Rampion Two Offshore Wind Farm

Appendix N6 to Natural England Deadline 6 Submission

Planning Inspectorate Reference EN010117

01 August 2024

**Rampion 2 Offshore Wind Farm**  
 Figure 8.16 Predicted worst case impact ranges for spawning sandeel from the sequential piling of monopile foundations (SELCum)

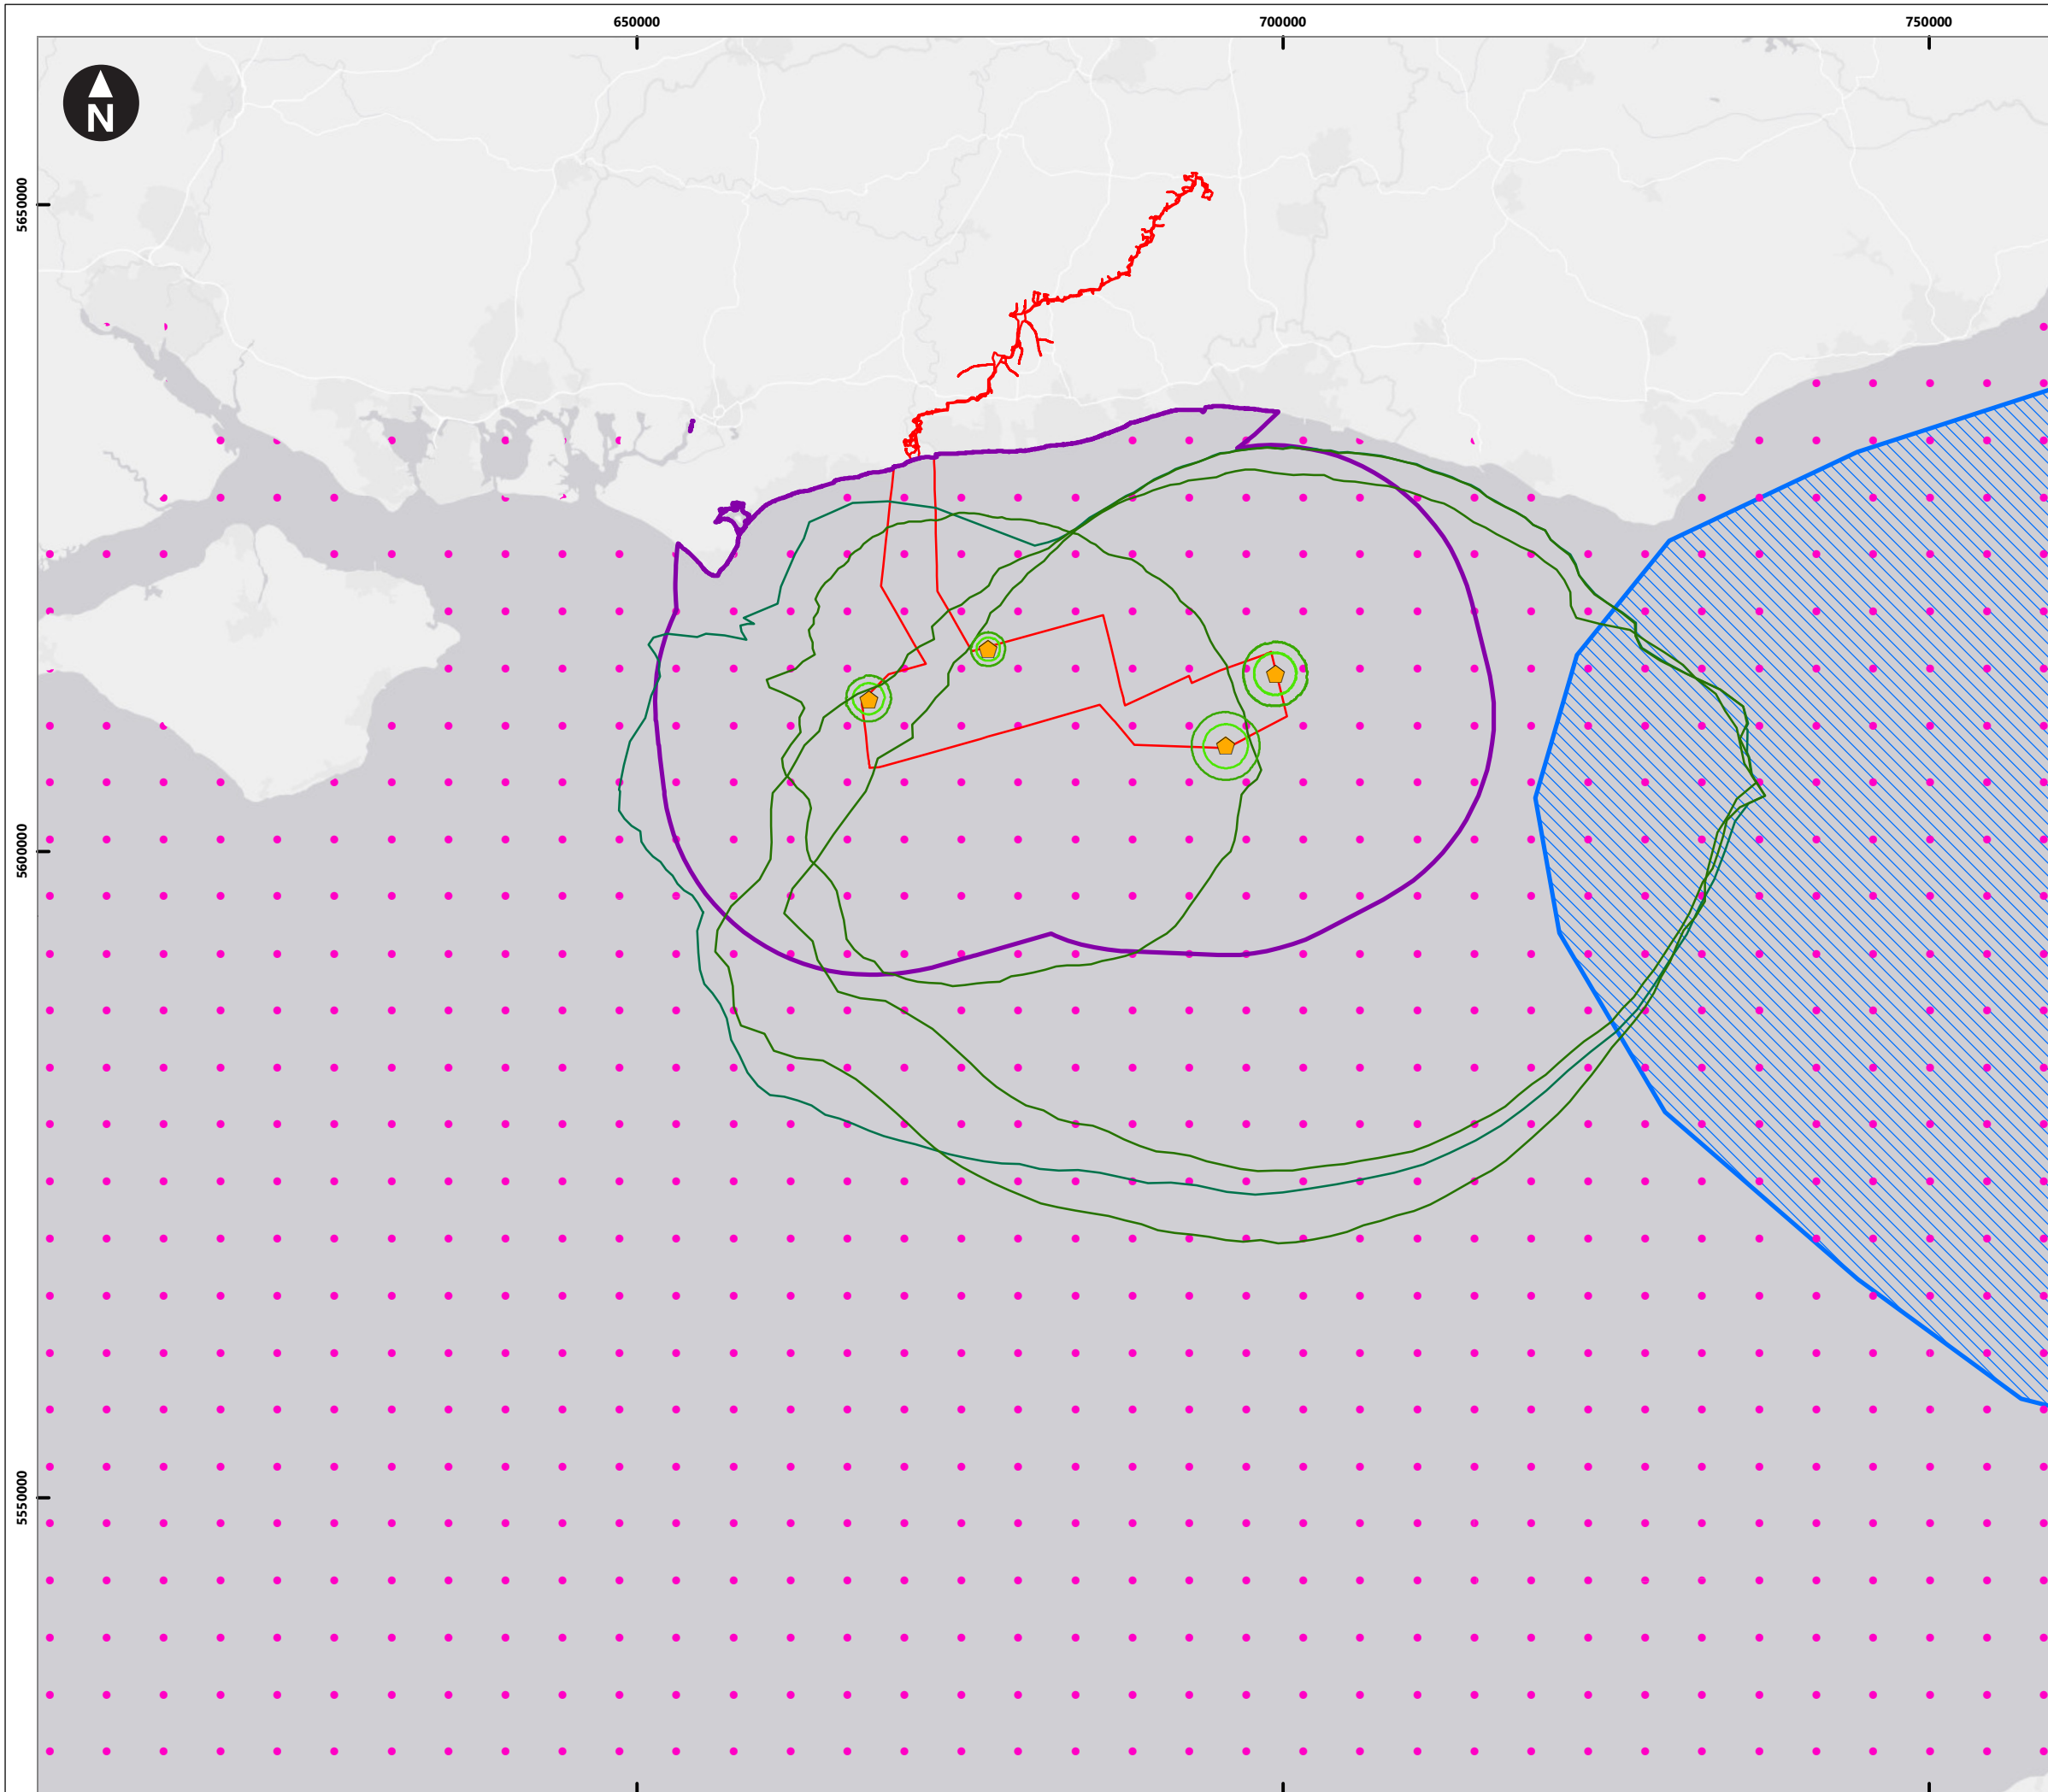
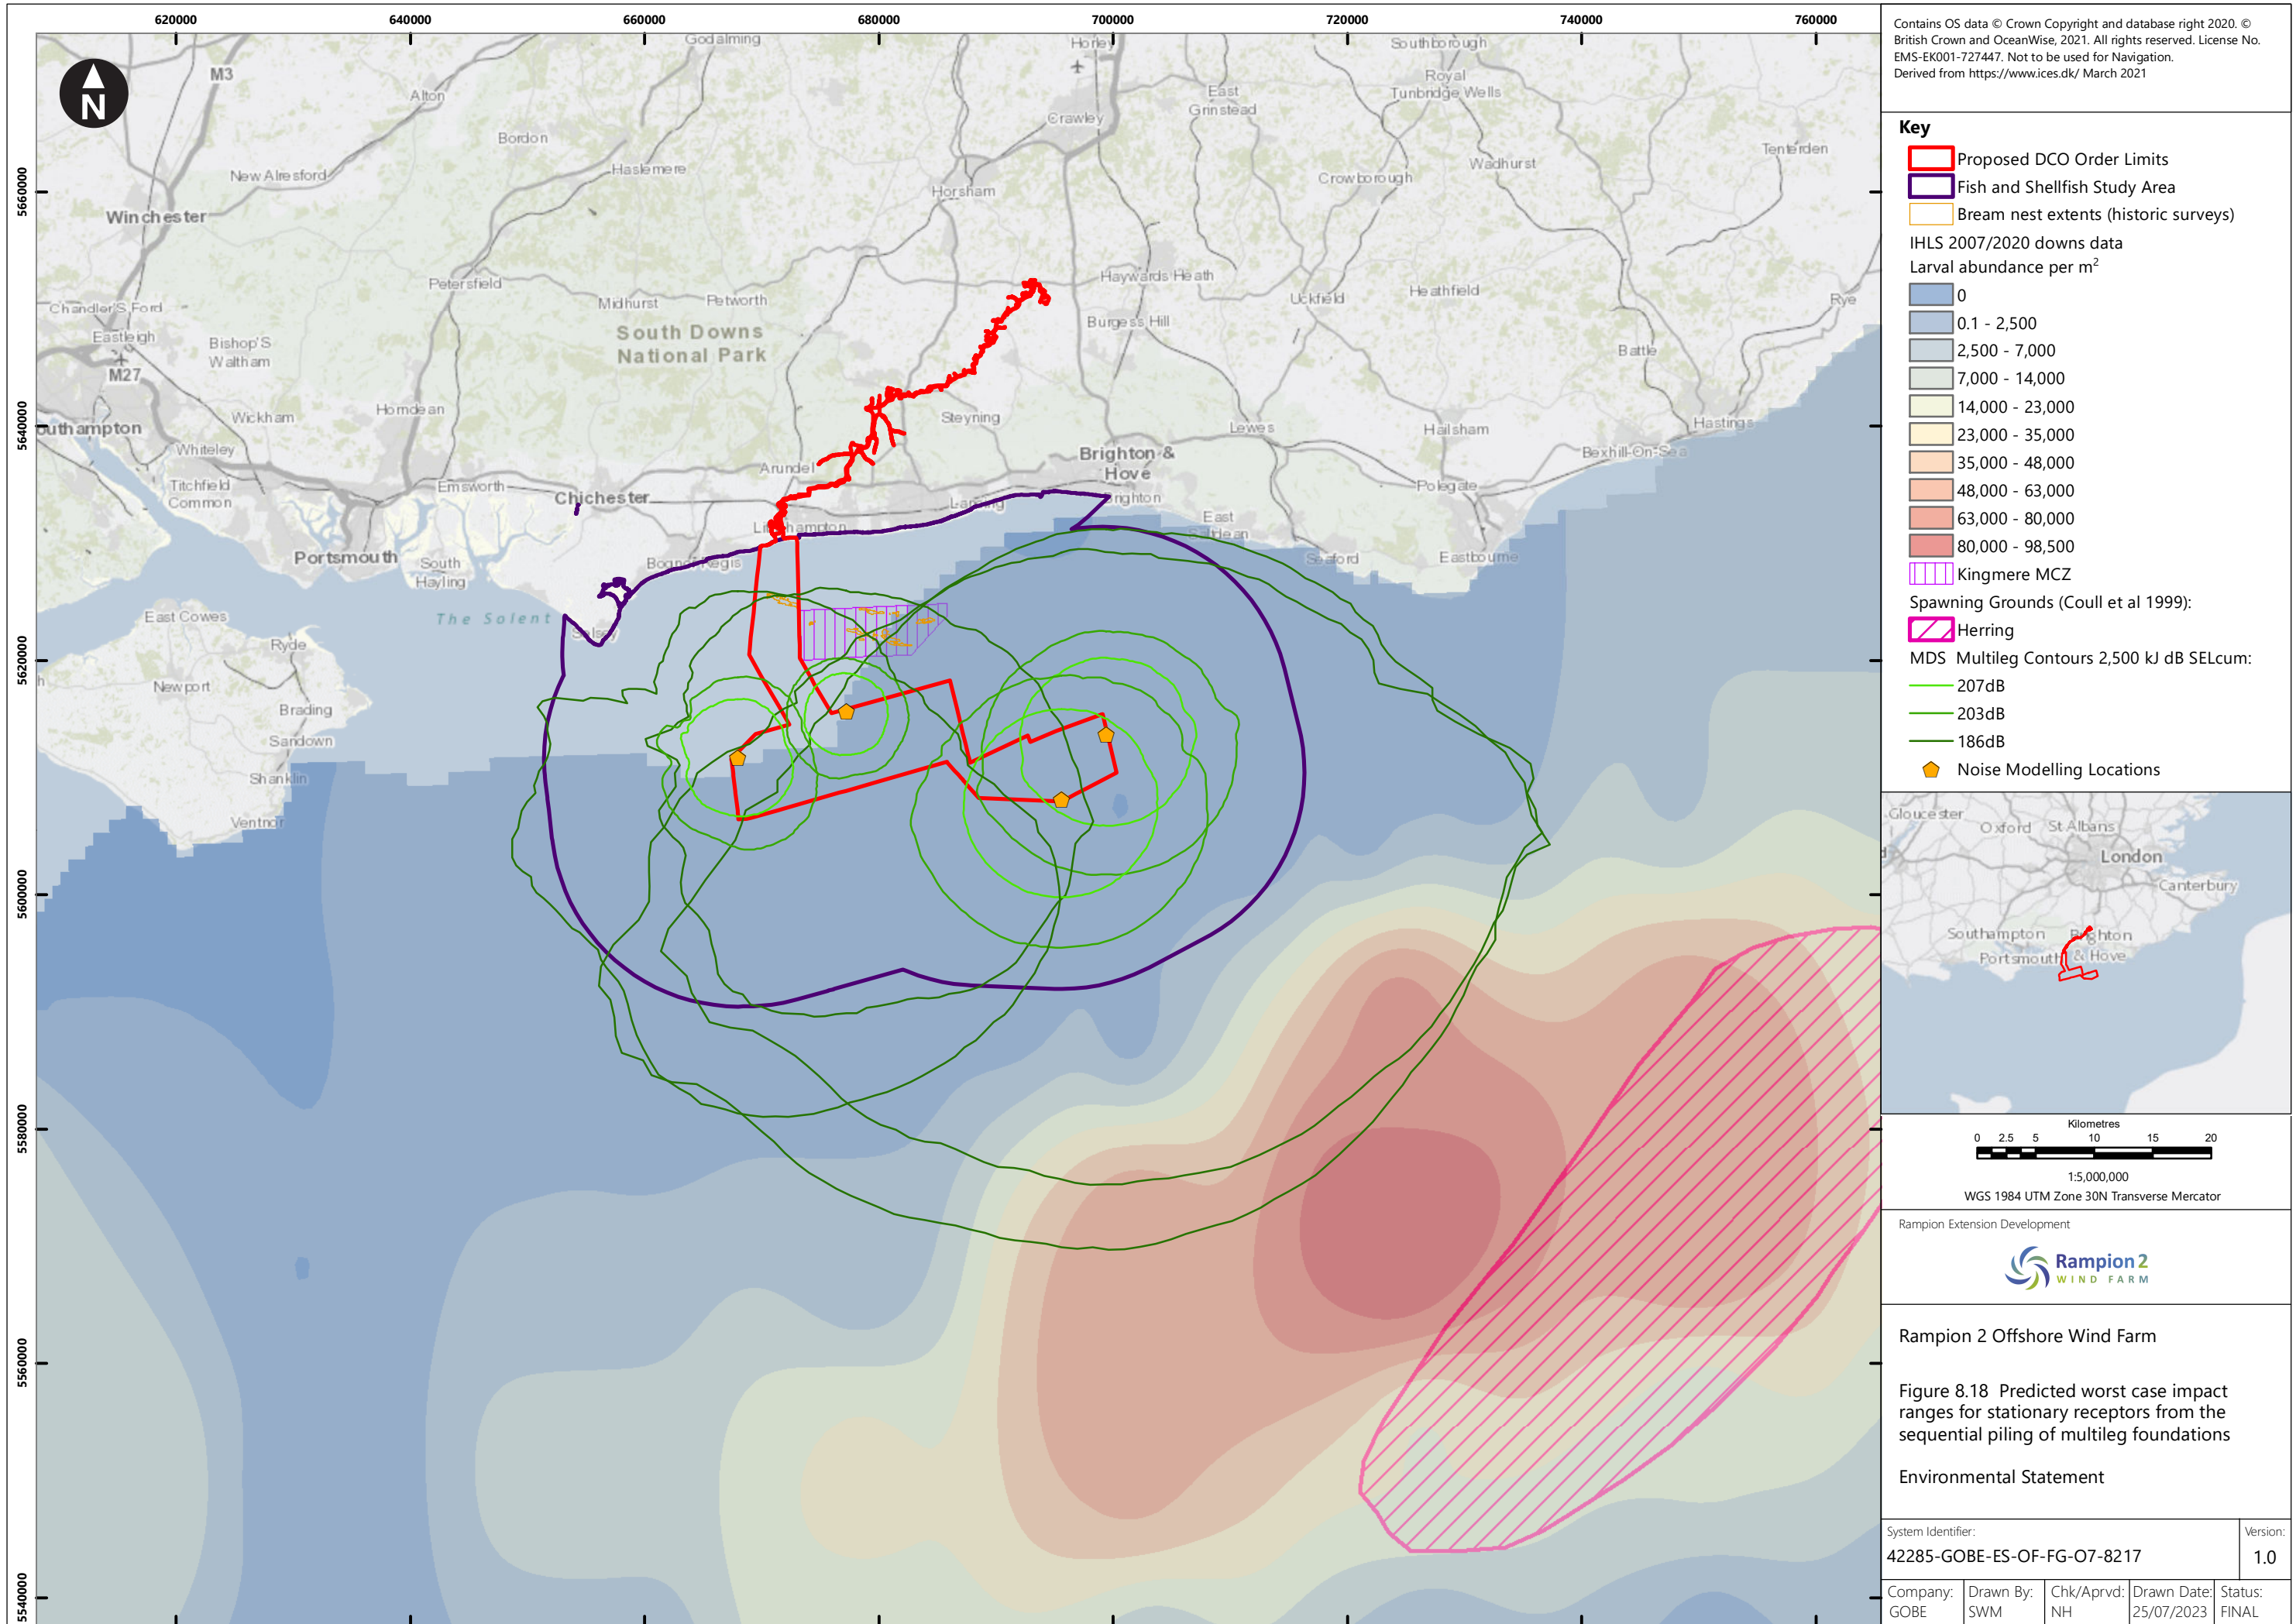
FS 3.1	<p><i>Worst Case Scenario – Piling Noise for Fish and Shellfish</i></p> <p>The Applicant Natural England</p>	<p>The ExA notes that Natural England has remaining concerns/questions with regards to the modelling of underwater noise and the worst-case scenarios for different situations [REP5-139,Page 2]. It states:</p>	<p>Natural England provided detailed comments on our position regarding fish and shellfish at Deadline 5. Where appropriate we have updated this position based on further information provided at Deadline 5 and provided directly by the Applicant on the 26/07/2024. Natural England have provided</p>

<p><i>“We advise that a clear explanation of whether sequential or simultaneous piling has been modelled as the worst case in each situation still needs to be provided and each figure needs to be clearly labelled with which scenario it is demonstrating. Additionally, as raised in our Relevant Representations (Appendix E, Point 27), where piling is conducted simultaneously at two locations we question what the closest distance between locations is likely to be, and how this is considered in terms of impacts on the MCZ’s.”</i></p> <p>The ExA also acknowledge that the Applicant has responded on these matters raised by NE, such as the response to Point E27 at Deadline 1 [REP1-017], for example</p> <p>The ExA requests the Applicant and Natural England resolve these issues before the close of the Examination. If the parties are unable to resolve these matters, provide a joint Position Statement and the options available to the Secretary of State.</p>	<p>updated advice in Appendix E6 of this submission on this point.</p> <p>Natural England has not seen a position statement from the Applicant.</p>
